Submission by the Community Environment Network
State Significant Development Application (SSD – 10321)

87-89 John Whiteway Drive, Gosford

Project Number	Drawing Number	Rev
19002	DA004.4	12
Coordinator: Approver	Checked: Checker	
Scale: As indicated @ A1	Date Printed: 28/05/2021 1:29:02 PM	
File Name:

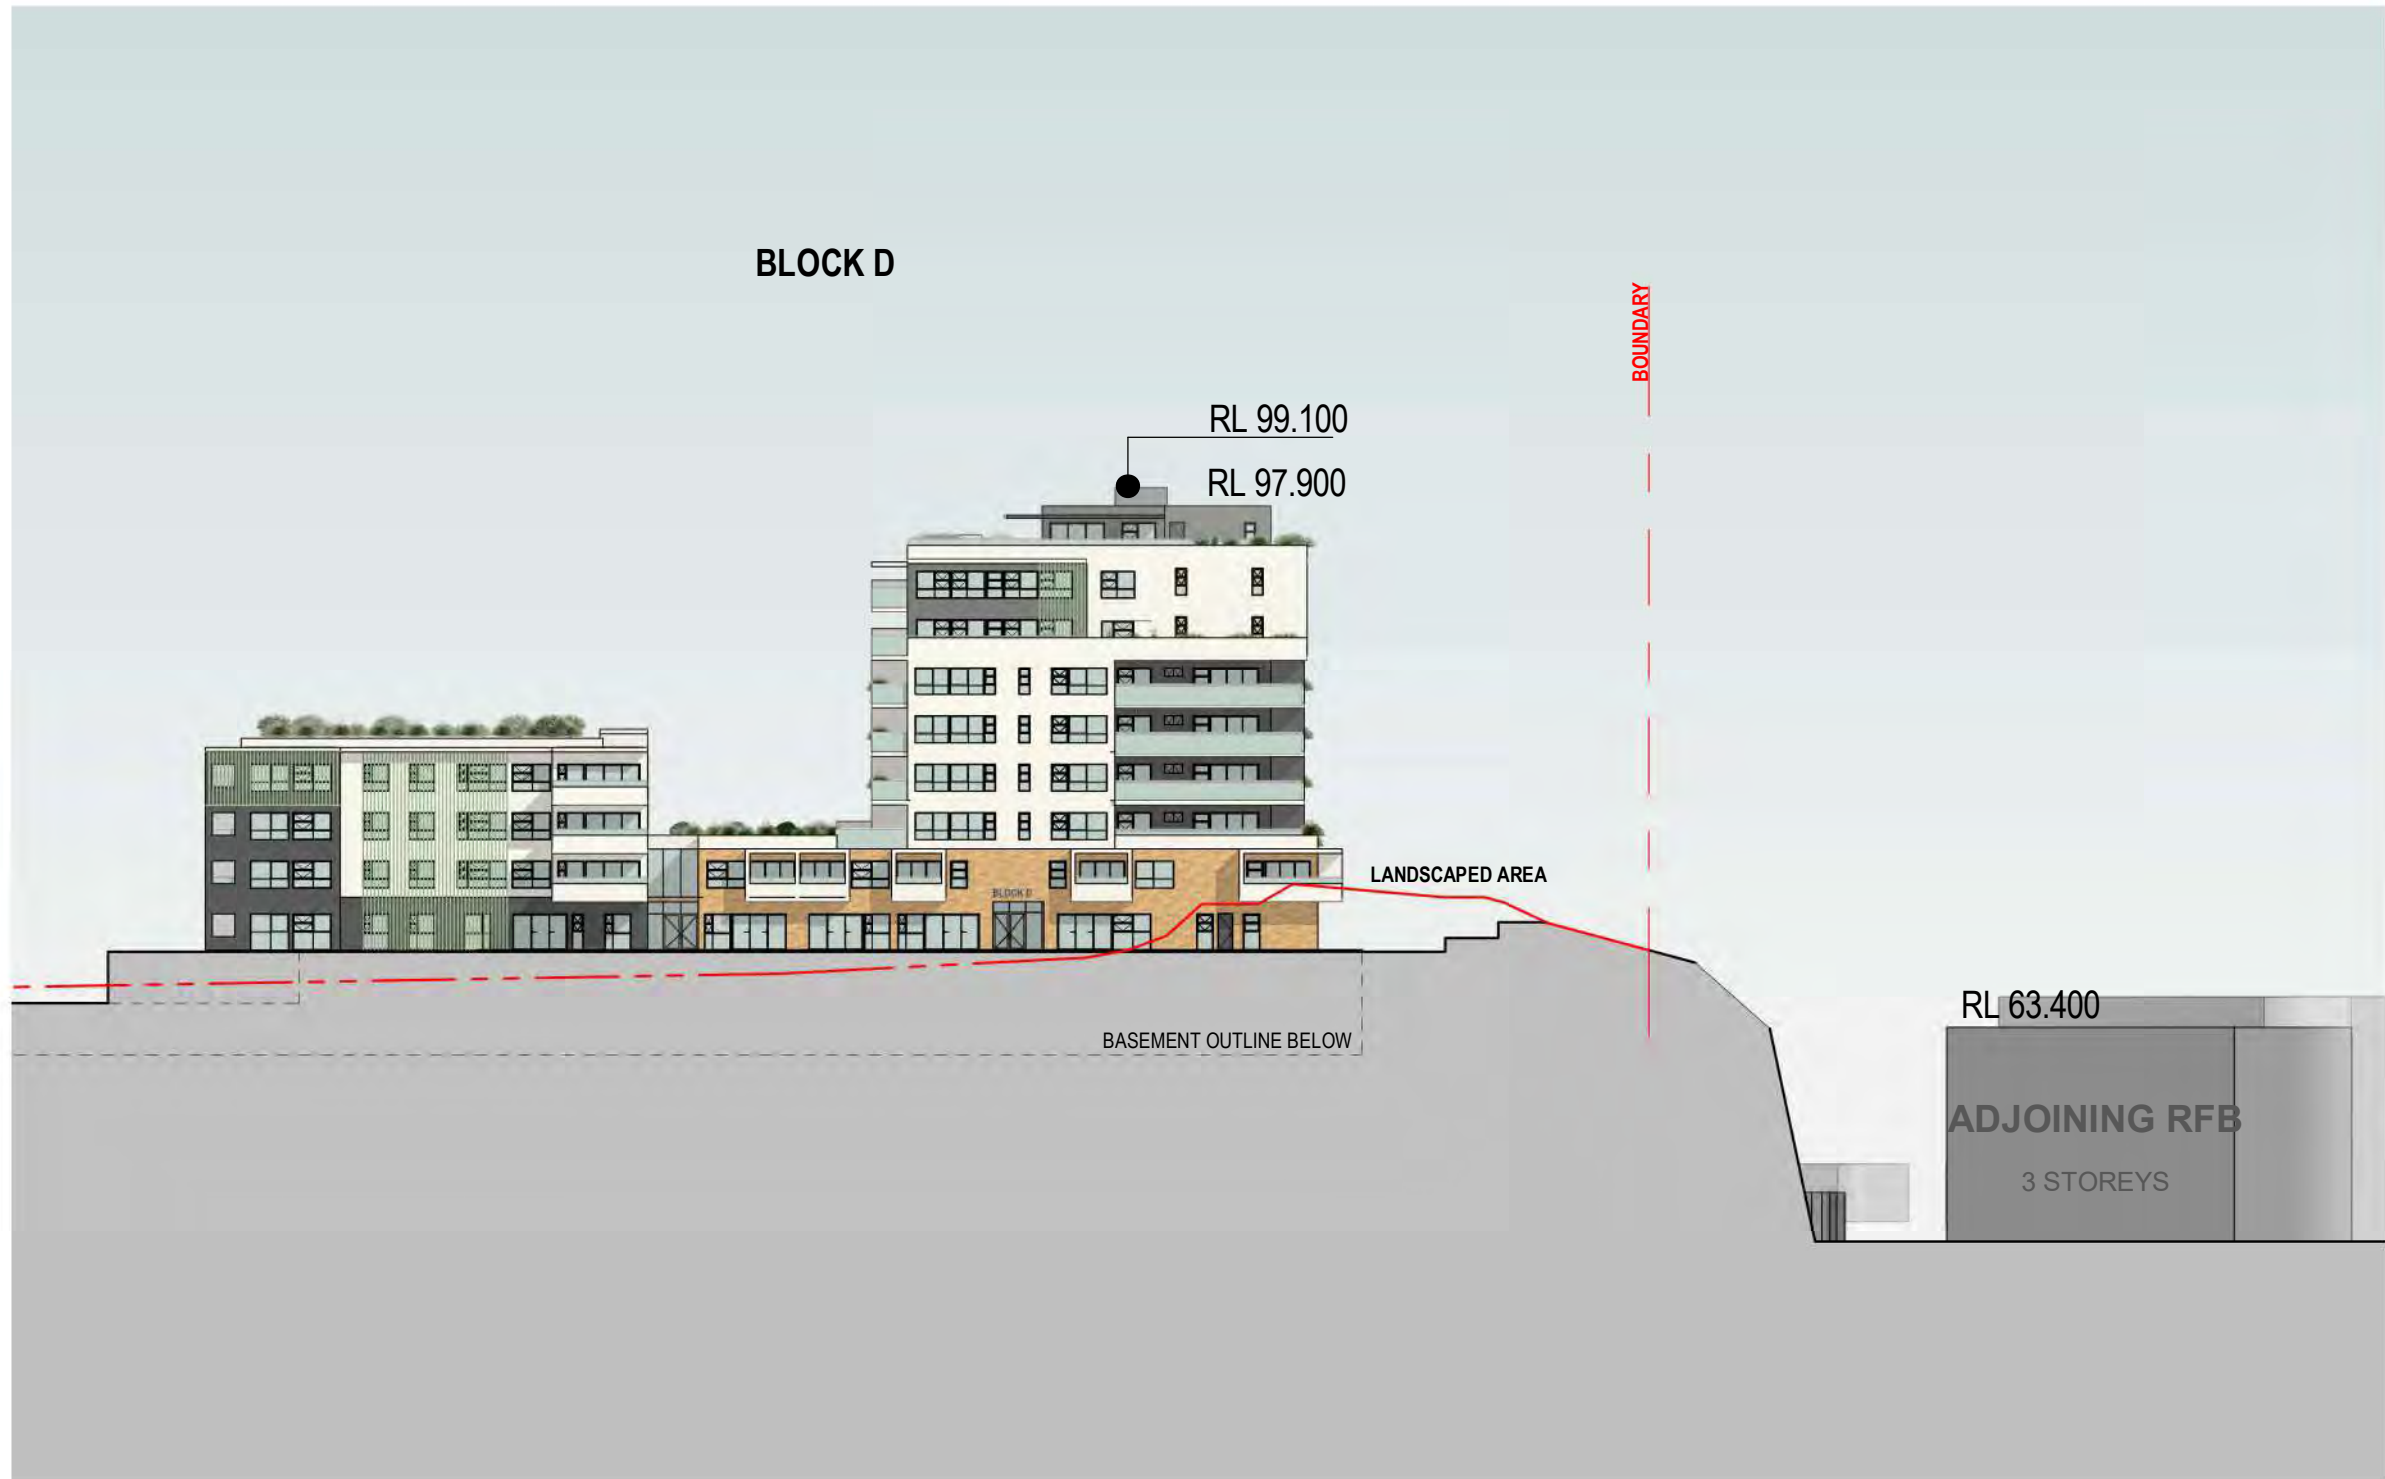
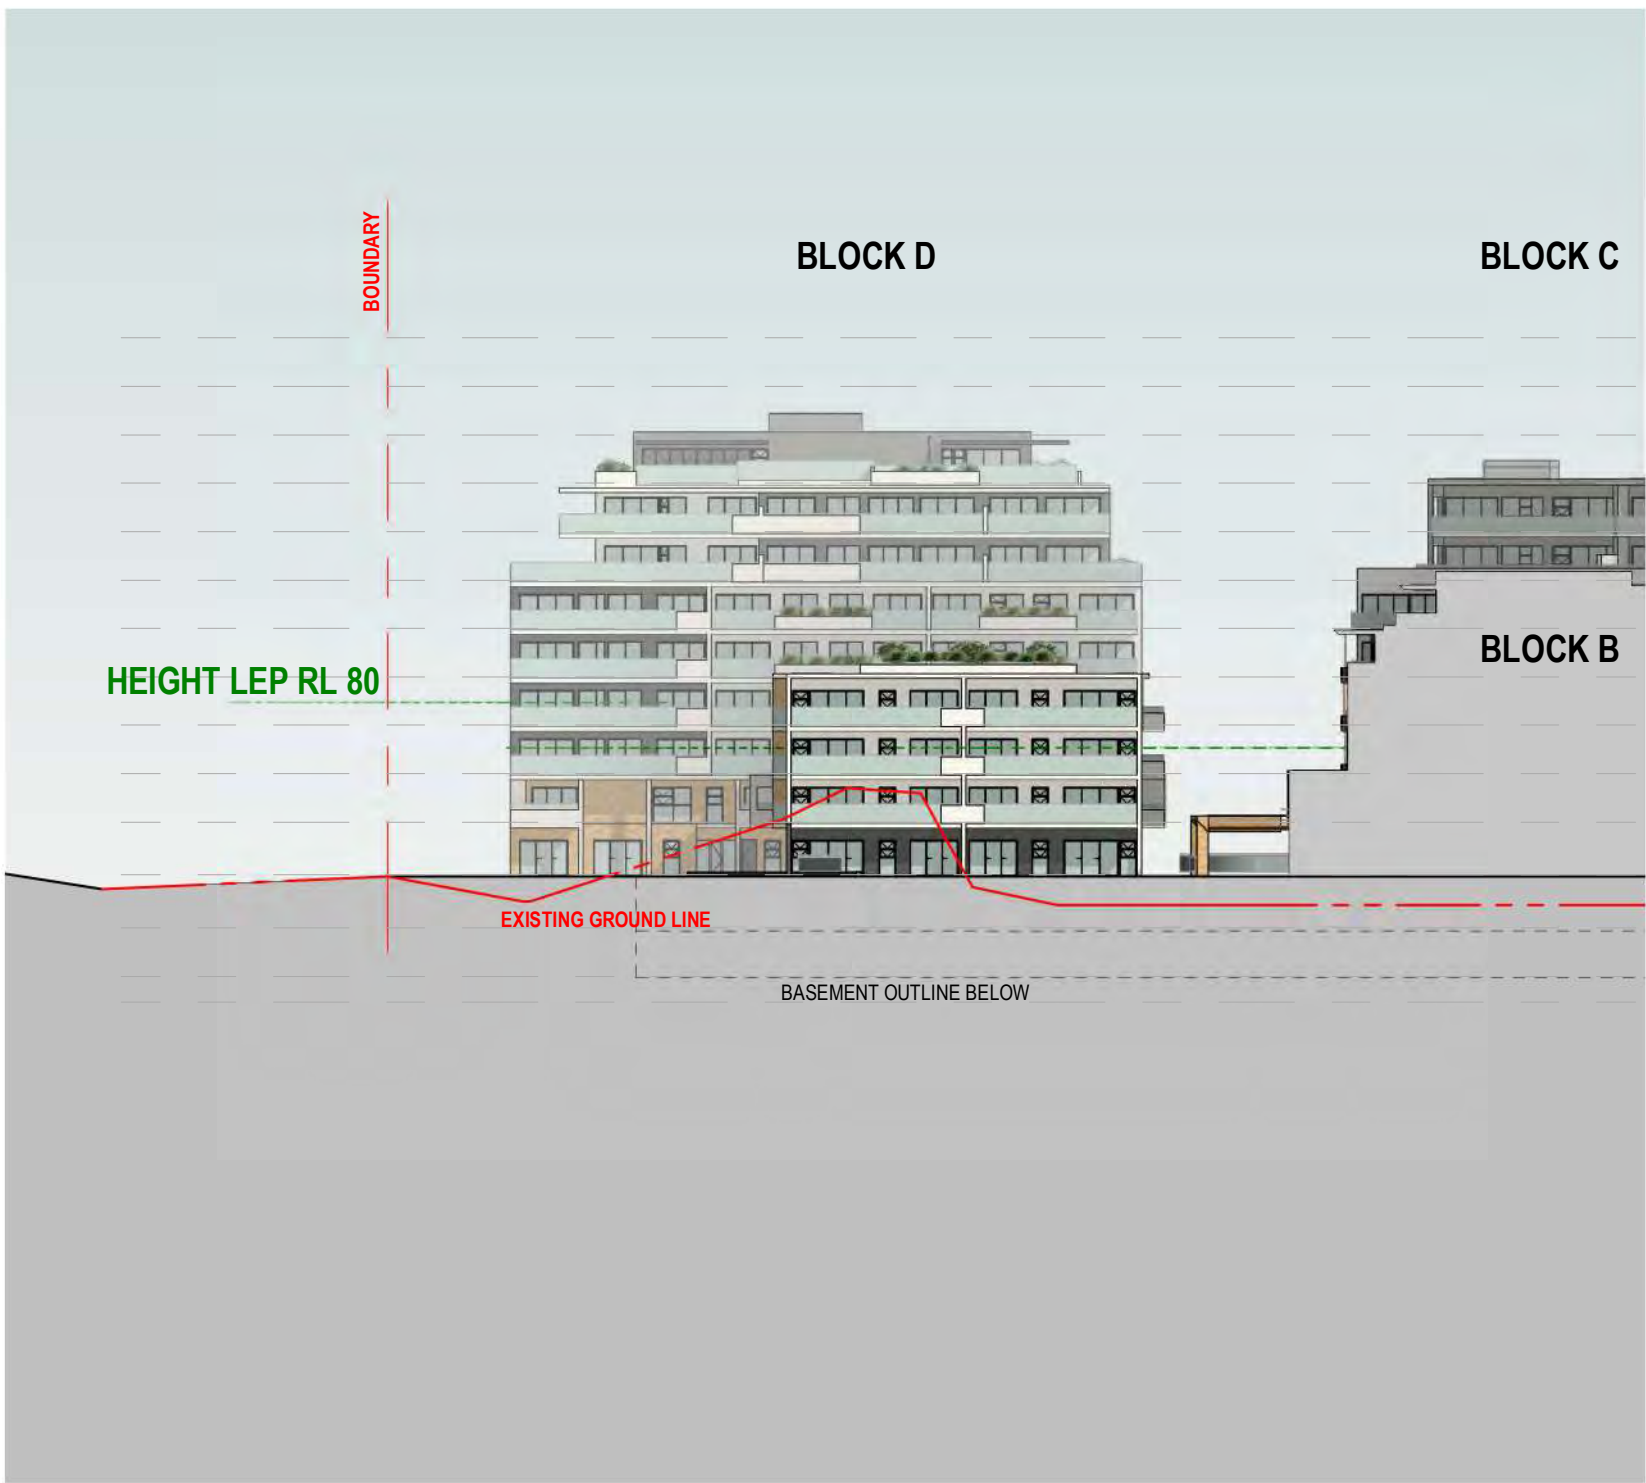
Consequently, the table demonstrates what massive increases in height are proposed by this “Clause 4.6 Variation Request”, in particular for Buildings C and D. Both buildings are proposed with heights exceeding the height limit by more than 300% of the permissible building height.

Despite the shortcomings in the Visual Impact report, it is concluded that Buildings C and D would be visible from most, if not all, viewpoints to the west and south-west of the site. It is likely that they will be on the ridgeline in those views, especially when the APZ is implemented.
